CITY OF ALBUQUERQUE

**RE: Car Crafters
5600 Holly Ave NE
Request 30-Day Temporary C.O. – Accepted
Engineers Stamp Date 1/29/15 (C18D044)
Certification Dated: 2/1/156**

CAR CRAFTERS
ENGINEER'S CERTIFICATION (HYDROLOGY) FOR PERMANENT CERTIFICATE OF OCCUPANCY

CAR CRAFTERS
GRADING AND DRAINAGE PLAN
ALBUQUERQUE, NM
PROJECT #14-032

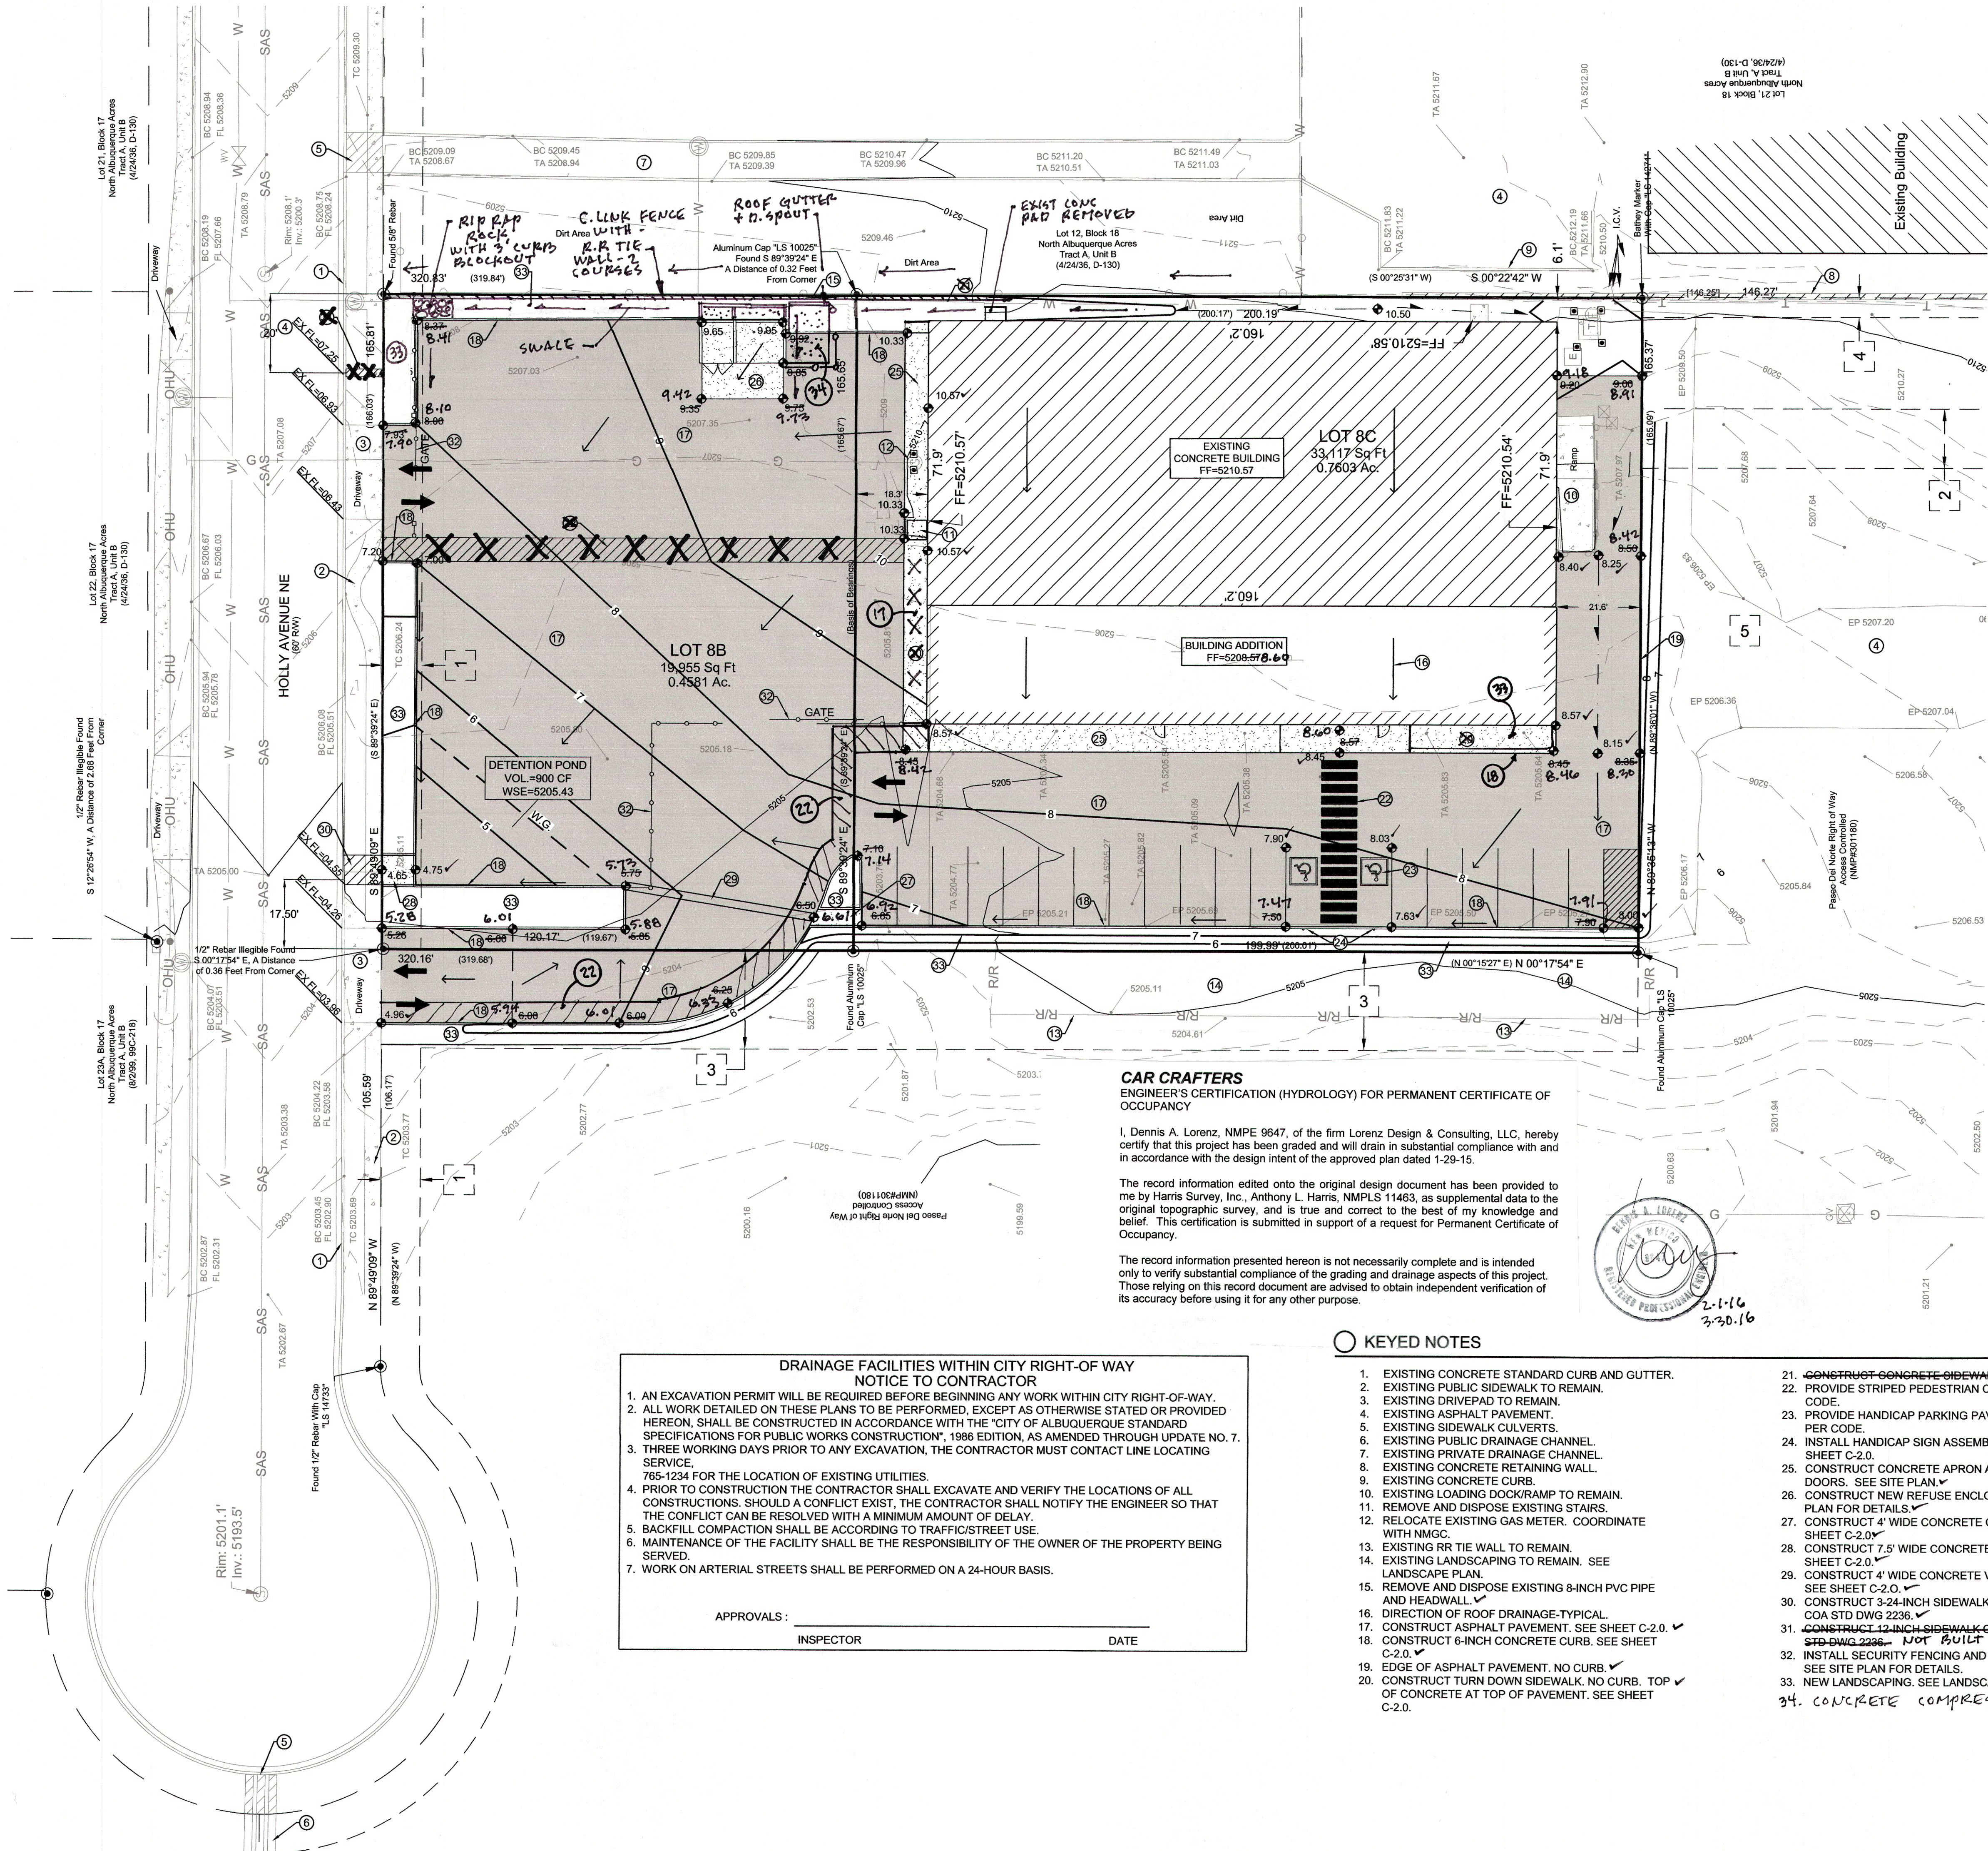
- On the east side of the building define swale to ensure that it does not discharge water to the adjacent site.
- Remove portion of stoop on east side of building so that it does not extend underneath the fence on to the adjacent site.
- Starting north of the above mention stoop, water draining north is blocked by the stoop. The swale does not exist from the stoop all the way to the NE corner and turning west at the fence corner. The swale must be defined so that water does not discharge to the adjacent site or the sidewalk north of the site. Overflow must be routed thru a sidewalk culvert.
- Provide new drainage calculations for 3'-7" channel on key note #27. The drawing calls out 4'-0".
